### Application for Planning Permission

**Development:** 1 No 4 bed chalet bungalow. This application is in CIL Zone 4 and is CIL Liable as a new dwelling.  
**Location:** Dawn Cottage 44 Pagham Road Pagham PO21 4NP

Proposed Ground Floor Plan

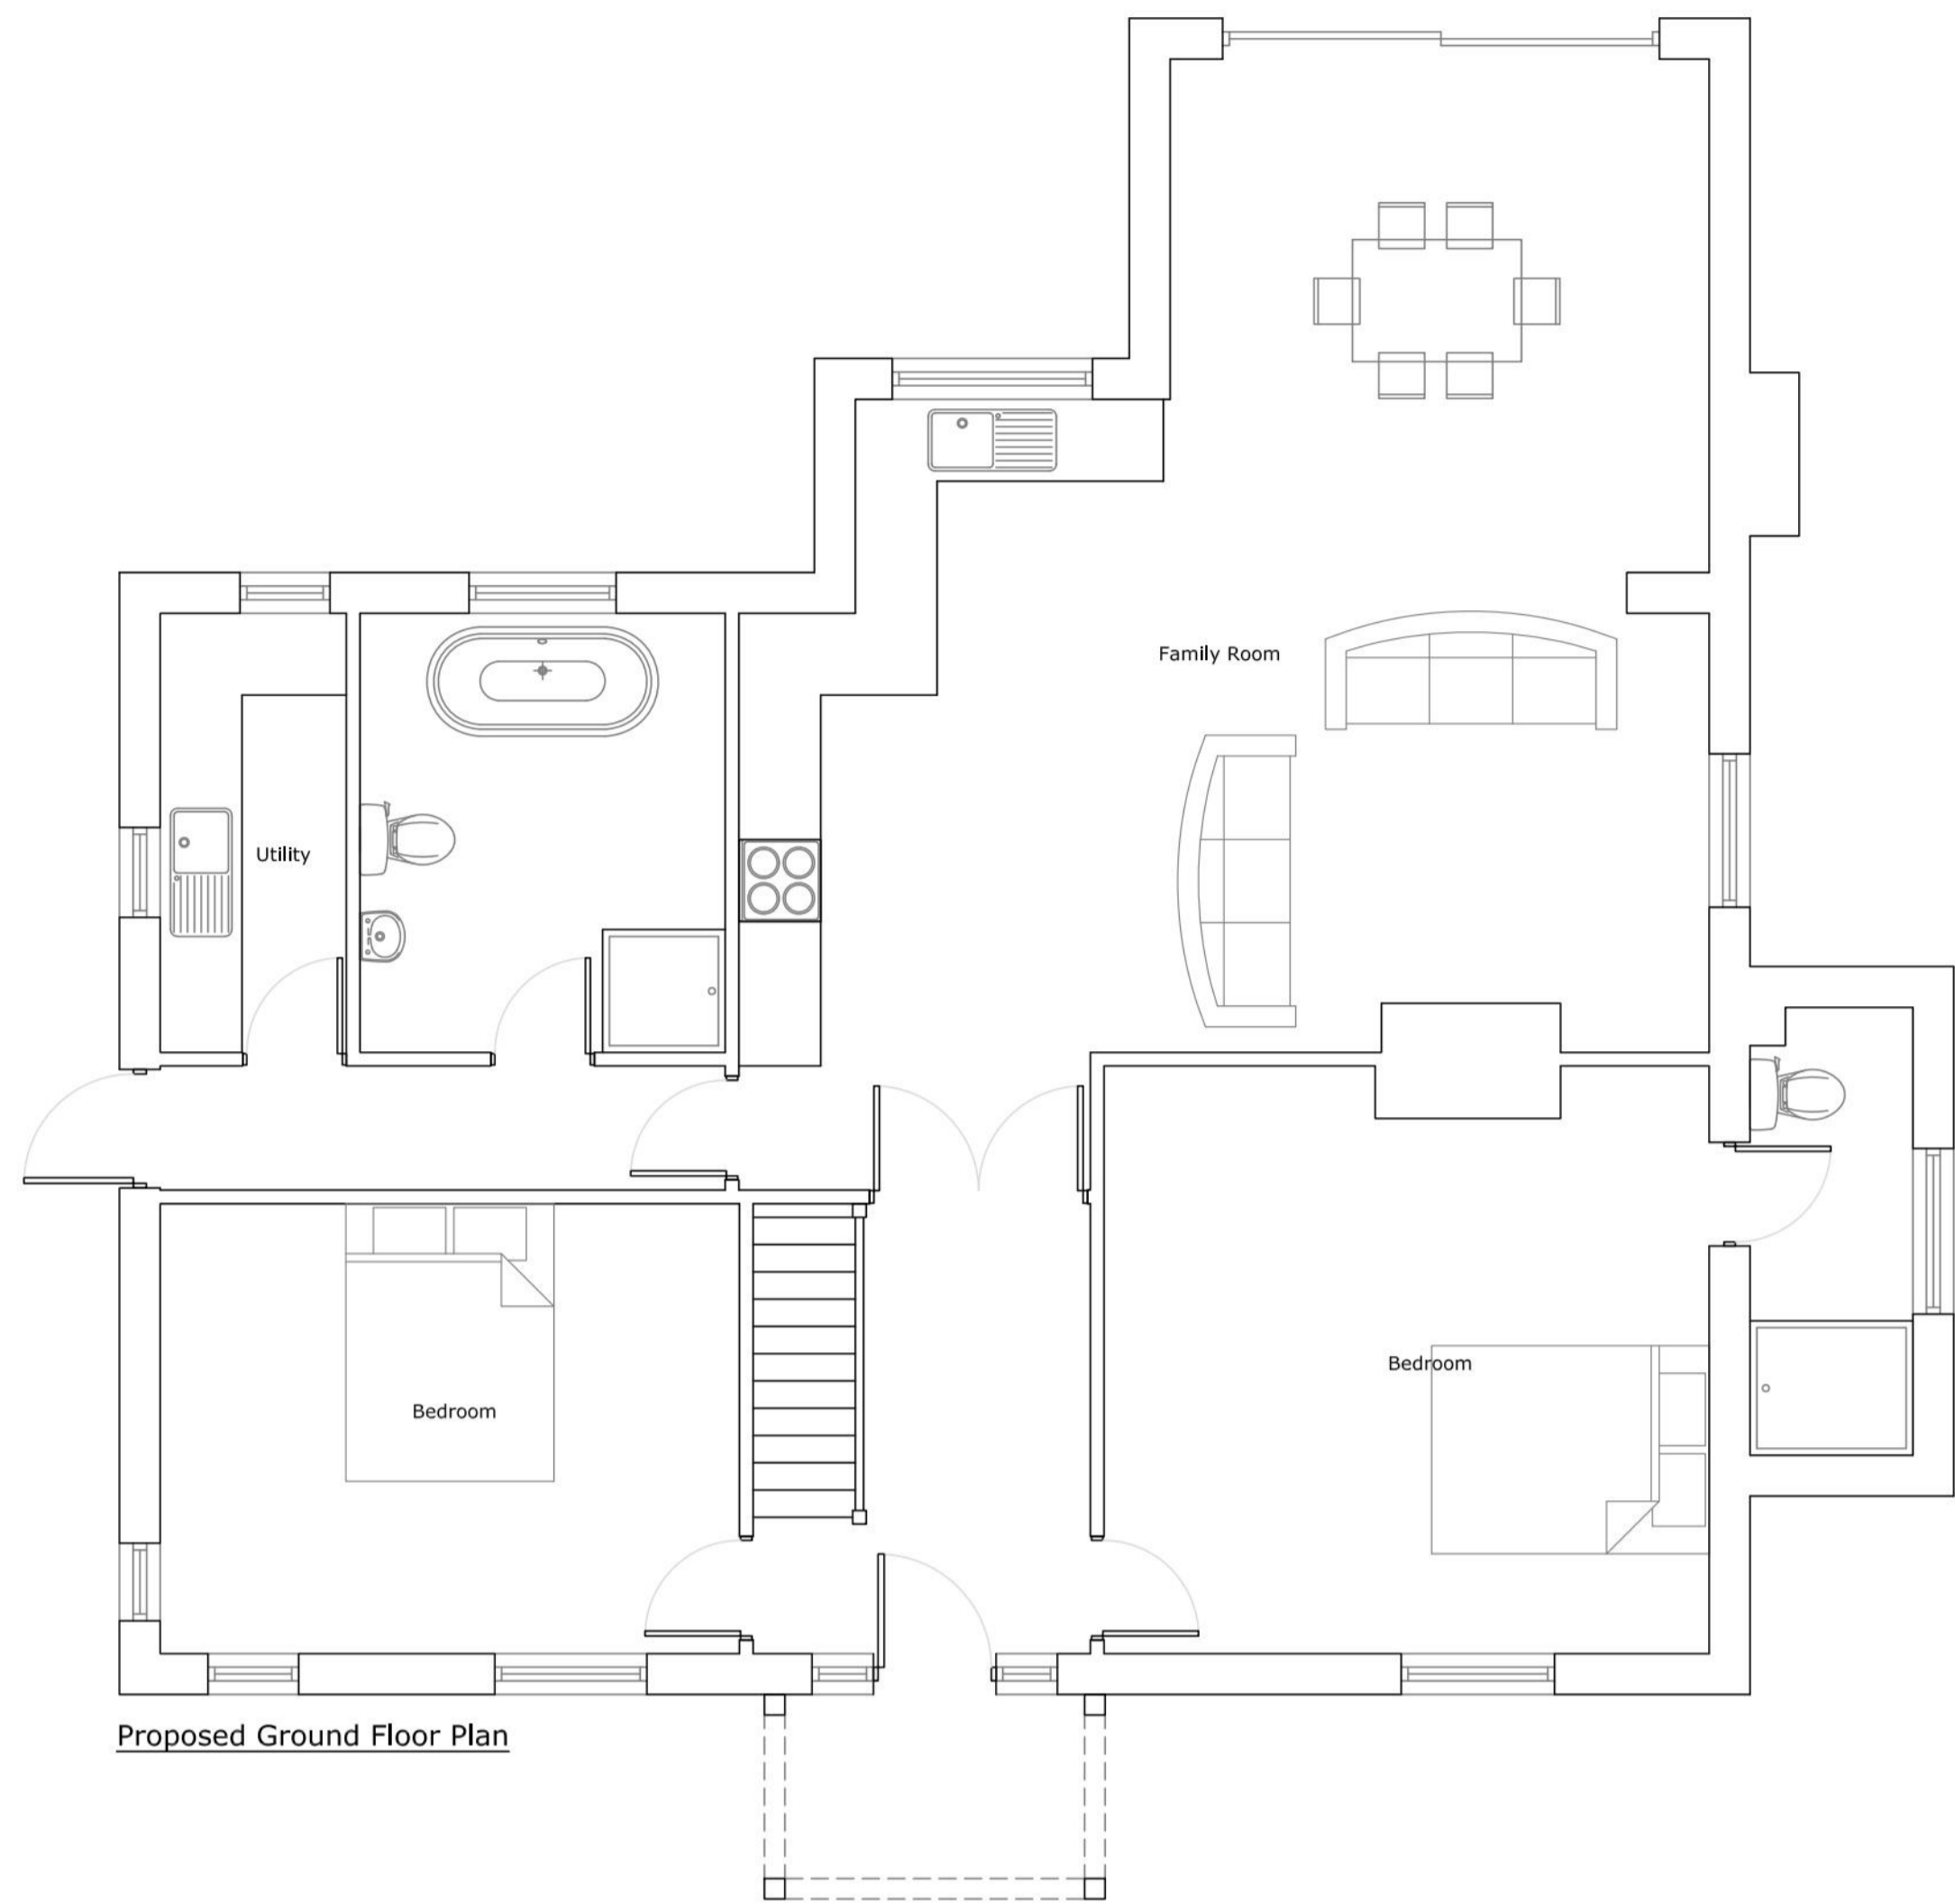
The proposed north elevation and ground floor plan do not accord. Please amend accordingly.

Proposed North Elevation 44A

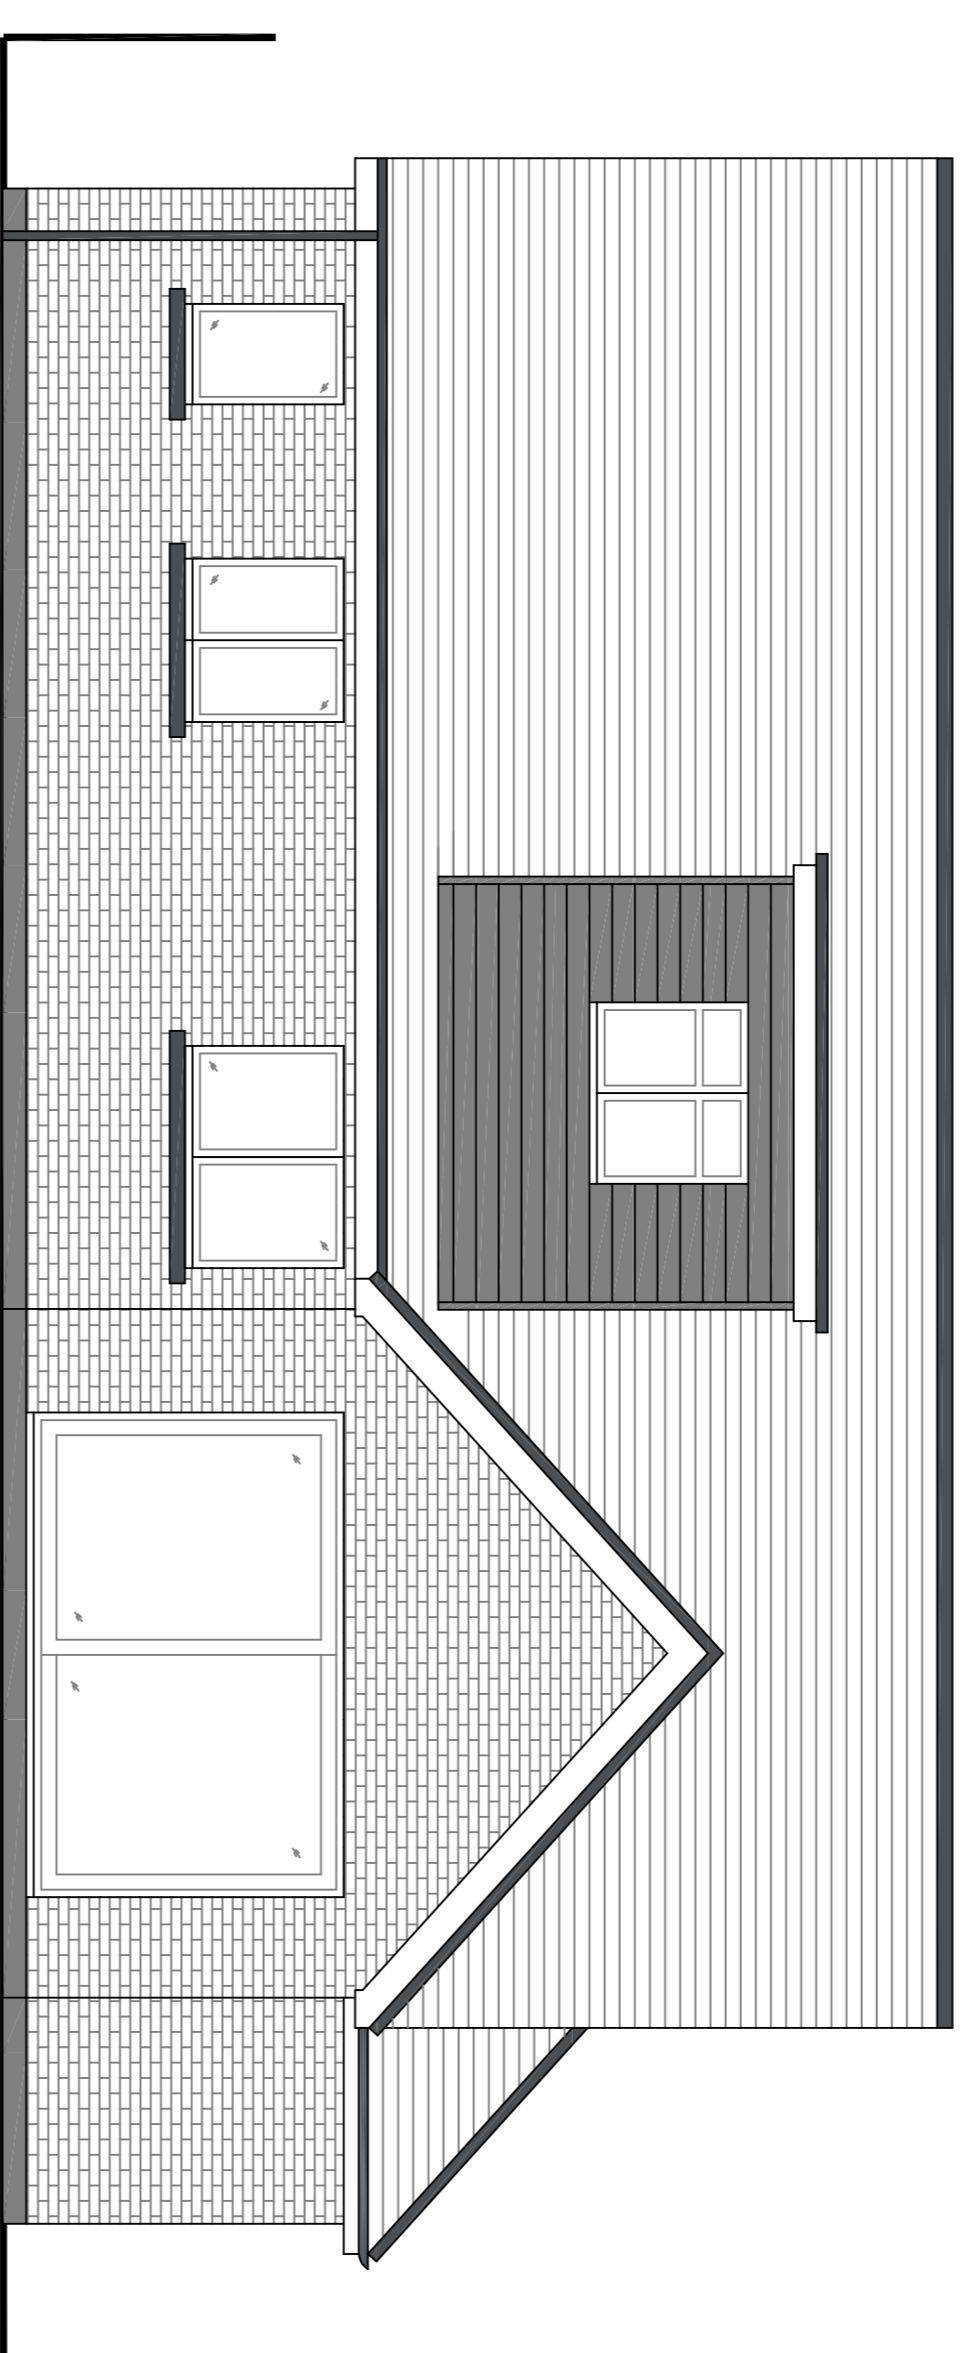
Please label the proposed north elevation.
